STATE OF NORTH CAROLINA  
DEPARTMENT OF TRANSPORTATION

September 27, 2004

Subject: **Application for Modification to Section 404 and Section 401 permits and Neuse Buffer Certificate** for the Northern Wake Expressway (I-540) from US 1 to US 64 in Wake County, Division 5. State Project No. 8.2401701, Federal Aid Project No. F-123-1(1), TIP No. R-2000 F&G; \$475.00 Debit Work Order 8.2401701, WBS Element No. 34365.1.1. NCDENR-DWQ Water Quality Certification Project No. 030114 and USACE Action ID 199920387.

The purpose of this submittal is to request a modification to the Section 404 permit and Section 401 Water Quality Certification and Neuse Buffer Certificate, specifically for Sections F&G. The modification for the permit is for several changes to jurisdictional and buffer impacts through construction modifications and to state discrepancies found by NCDOT personnel between the permit drawings and the construction plan sheets.

# PLAN VIEW SITE 10

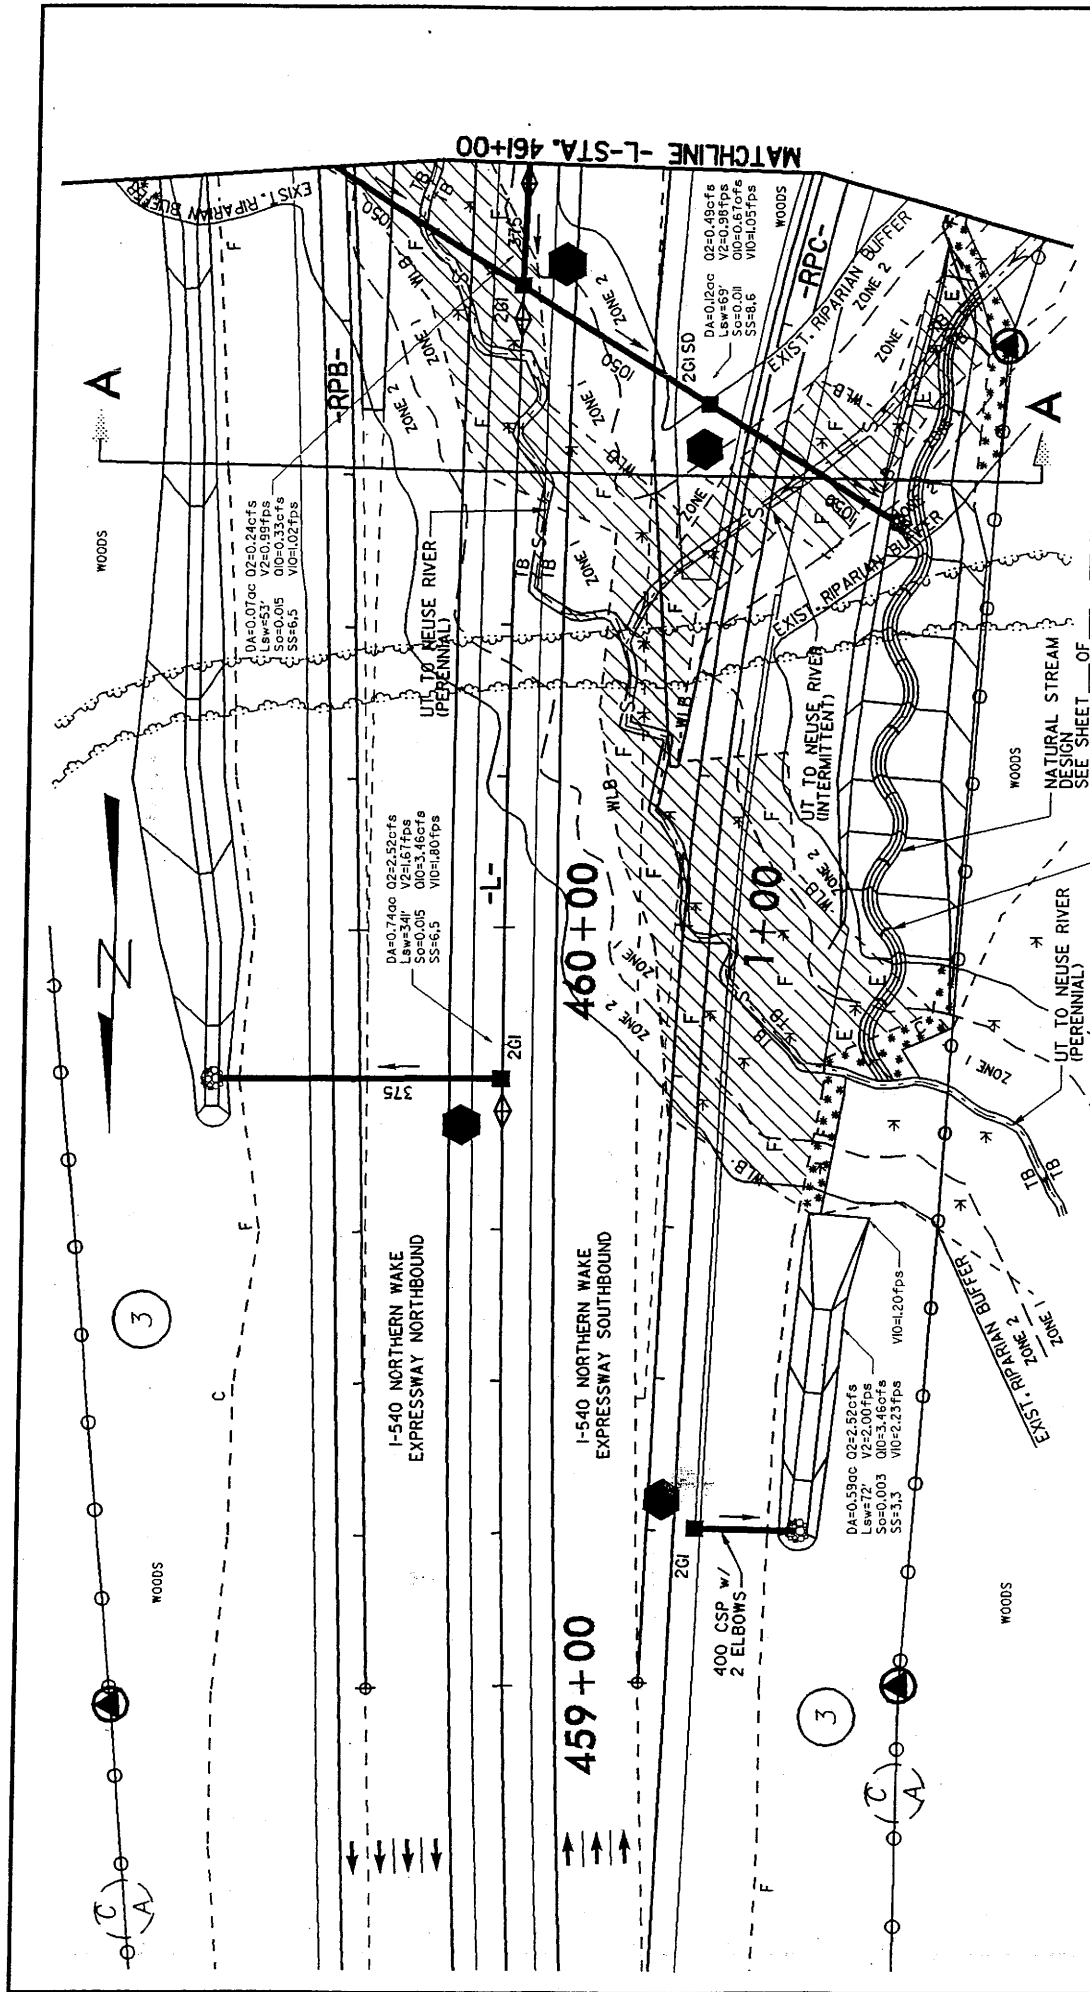
Modifications were made to the Natural Stream Design on the permit drawing and plan sheet. This information was requested by the Corps. This consists of widening the floodplain by 2.4 meters (7.9 feet) to ensure appropriate floodprone width is obtained. Rock cross vanes will be moved from the glide to the run in order to enhance the downstream pool as well as the armored riffle. A rock cross vane will be installed at the outlet of the 1050 mm pipe with the

invert of the cross vane set at the invert of the pipe. The cross vane will help dissipate the energy created by the pipe as well as enhance the pool downstream of the pipe. No changes to jurisdictional or buffer impacts.

R-2000 F
 sheet 87 of 90
 Rev. 5/2/06

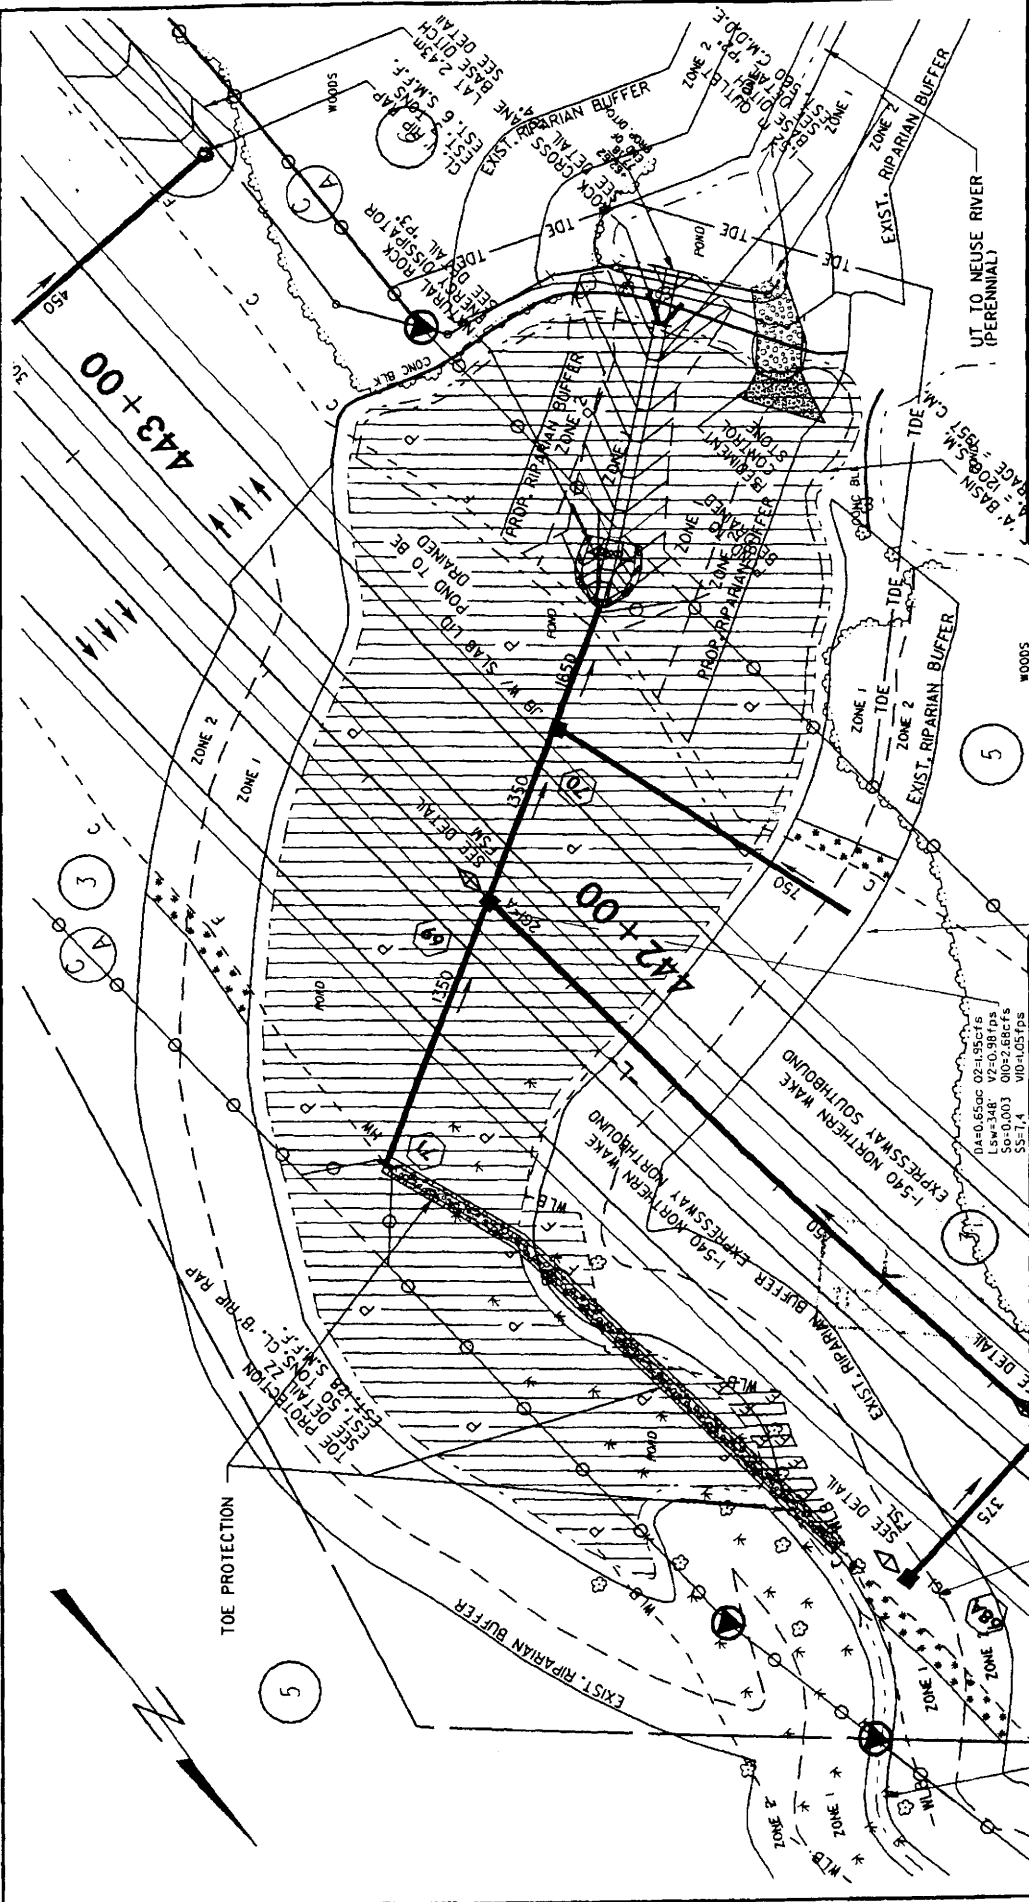
Permit Drawing revised to reflect change in lateral base ditch from Permit Drawing 63.
